# ADDITIONAL INFORMATION REPORT

MP 11\_0048

61 MOBBS LANE, EPPING – STAGE 2

MARCH 2012

March 21, 12pm

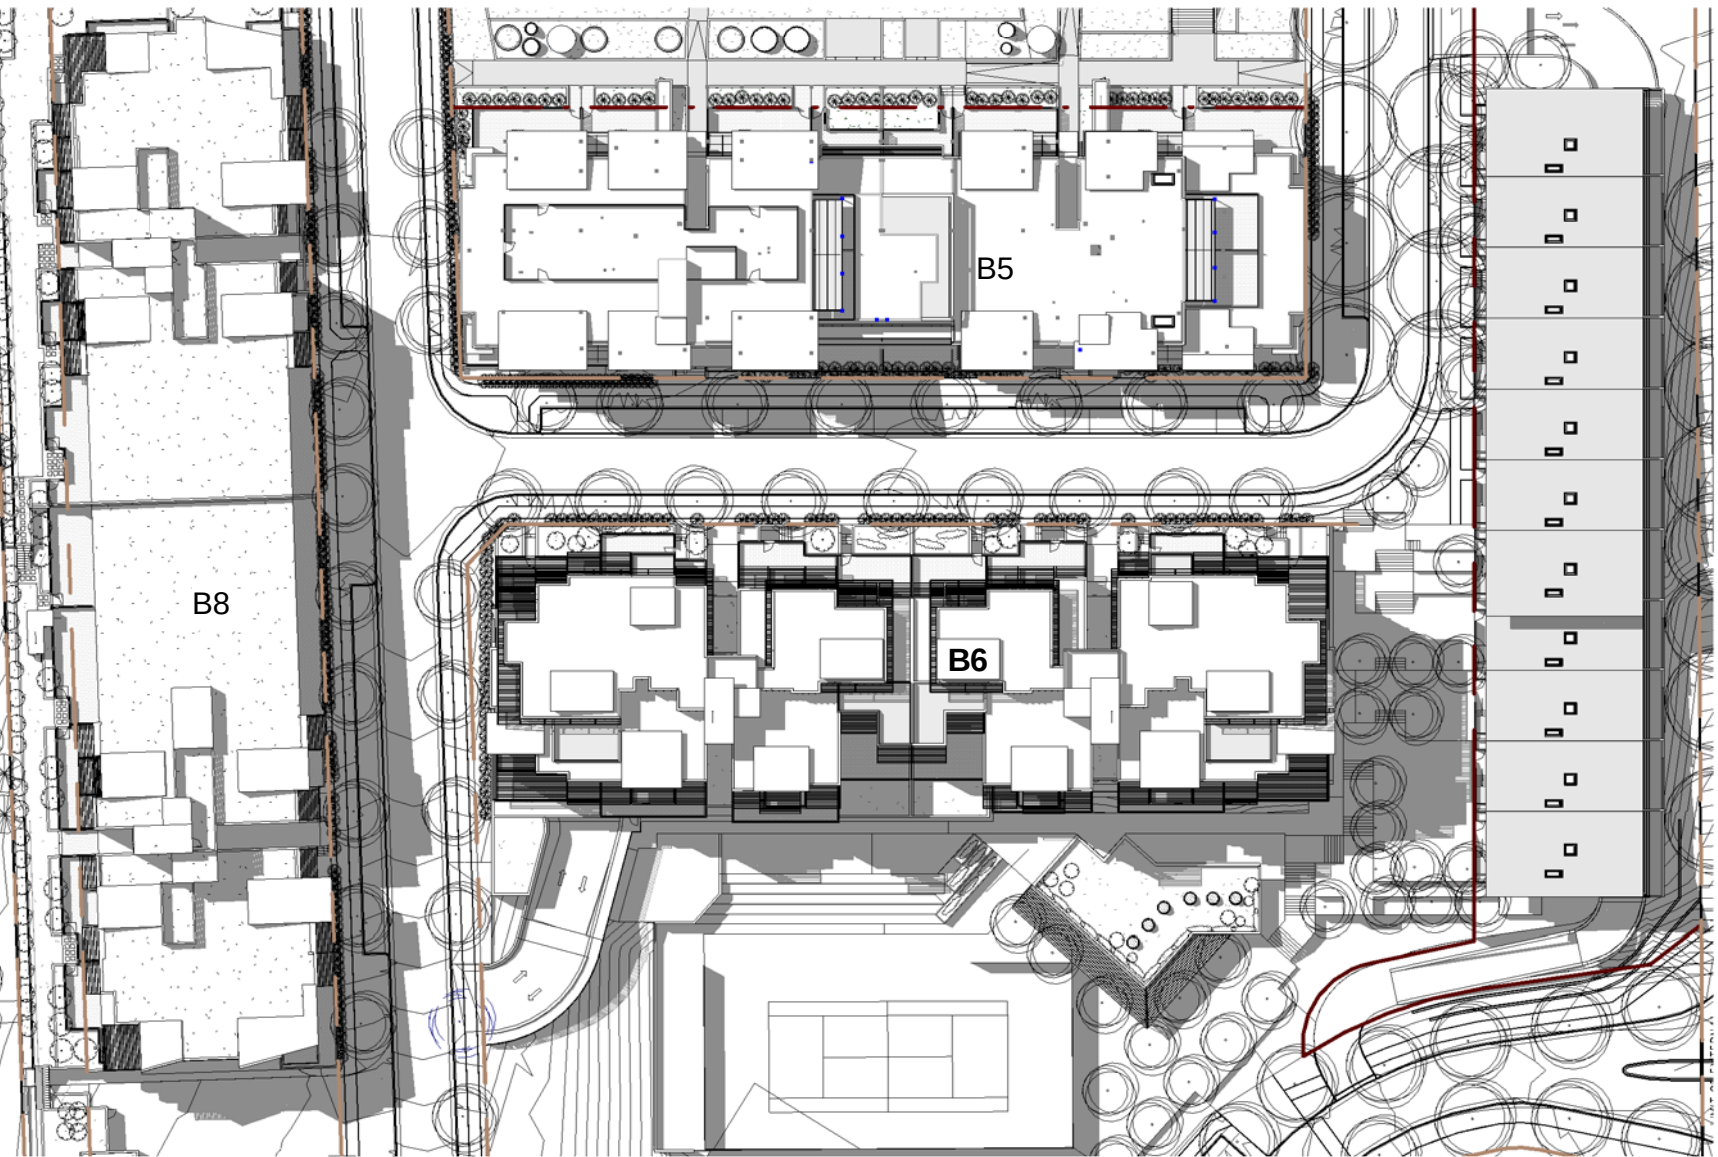
**Issue:** Shadow diagrams to be amended to include tennis court.

**Response:** Shadow plans have been corrected. Refer to ***Annexure 3***.

1 EAST ELEVATION
1 : 100

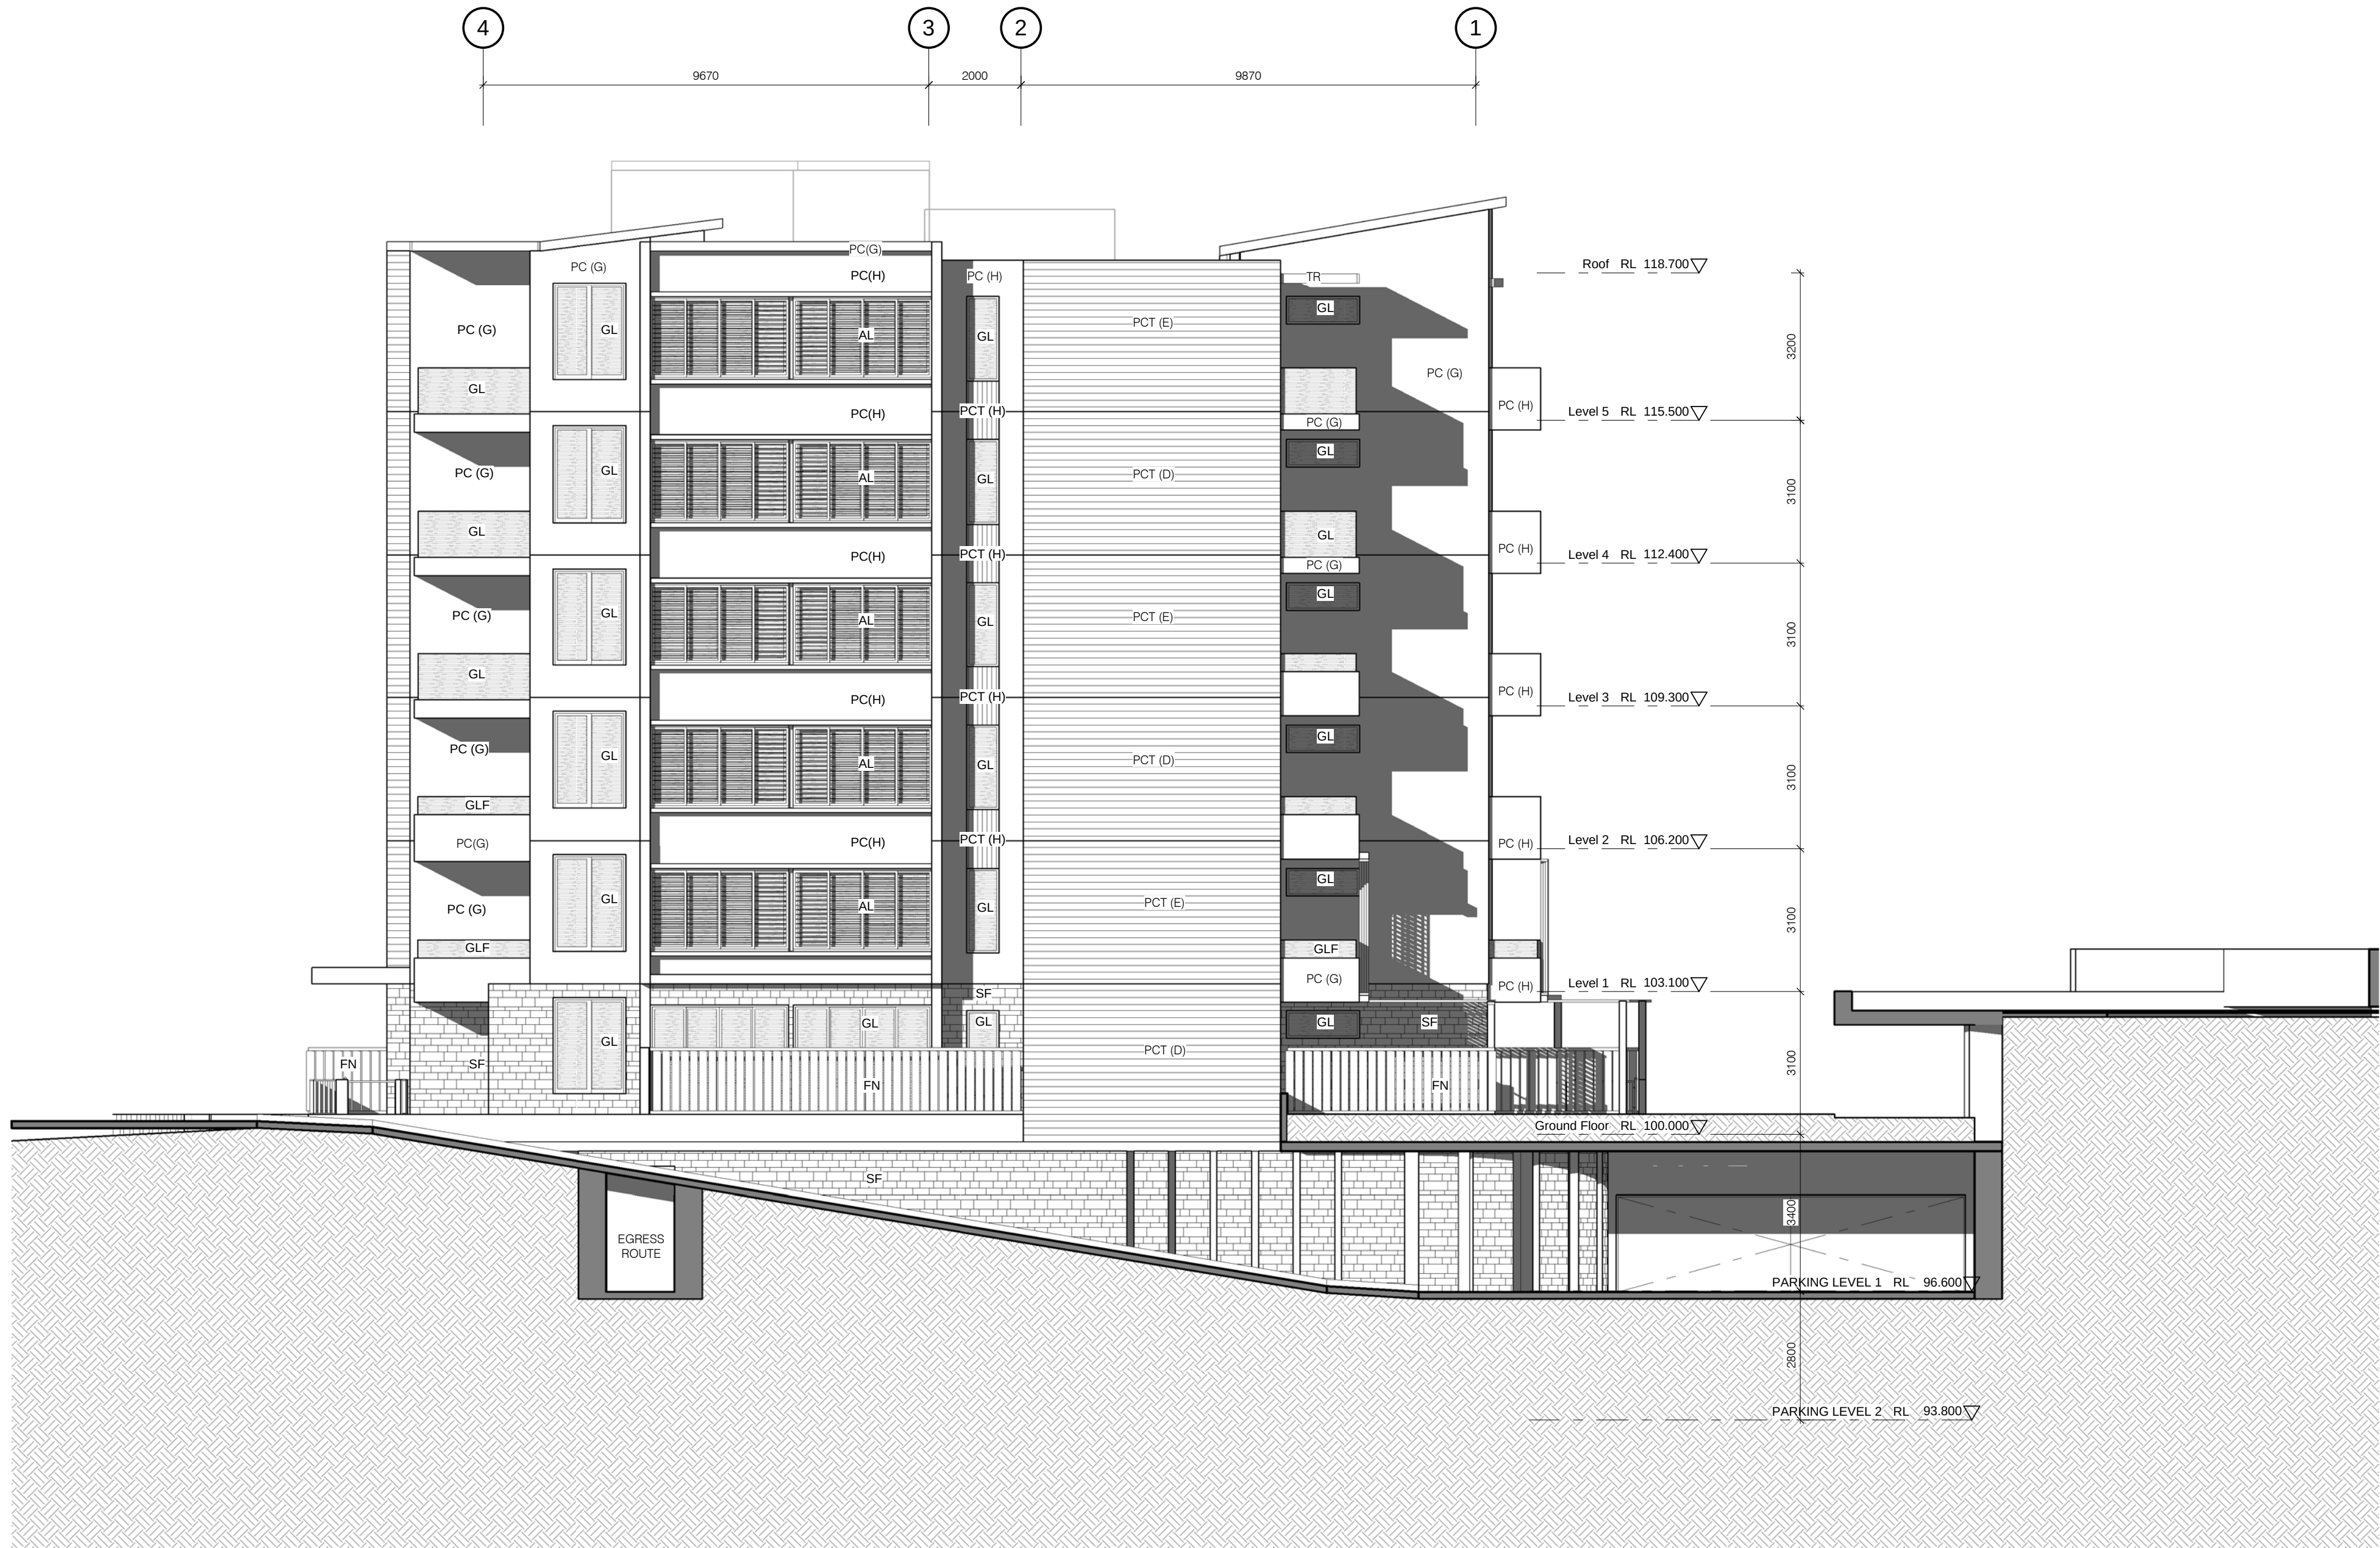
**Issue:** The east, west and south elevations do not show roof and plant details.

**Response:** Plans have been amended accordingly. Refer to ***Annexure 3***.
